Glendell Mine – Modification 3 (DA 80/952 MOD 3)

Thank you for forwarding the Environmental Assessment (EA) for ARTC's review, accordingly I advise that the proponent has made representations to ARTC to facilitate the relocation of the existing 132 kV Ausgrid powerline at the Glendell Mine.

Figure 2: Proposed transmission line alignment

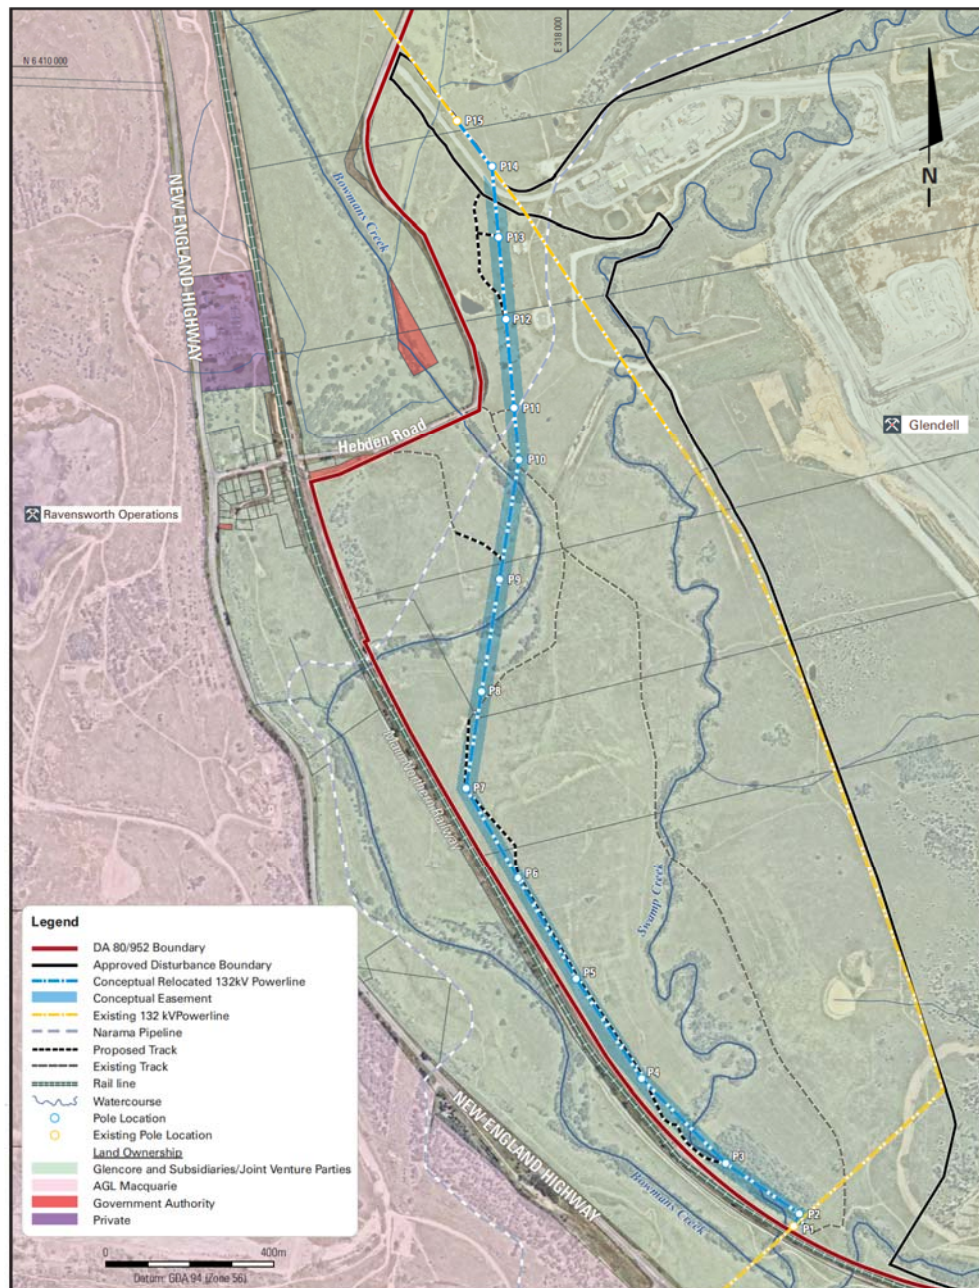
Accordingly, the proponent and ARTC will continue to liaise throughout the project with respect to the overhead crossing of the Main Northern Railway, subject to;

1. Final design plans complying with ARTC Standards, Australian Standards, Heavy Haul Infrastructure Guidelines and any reasonable requirements of ARTC and the design is to consider the following;
 - All structures supporting a span of electric aerials over ARTC railway tracks or sidings shall be so located that in the event of failure no part of them will fall within 1.8m of the outside rail of any railway track in accordance with PYS 02, and
 - Potential induction with existing ARTC infrastructure.
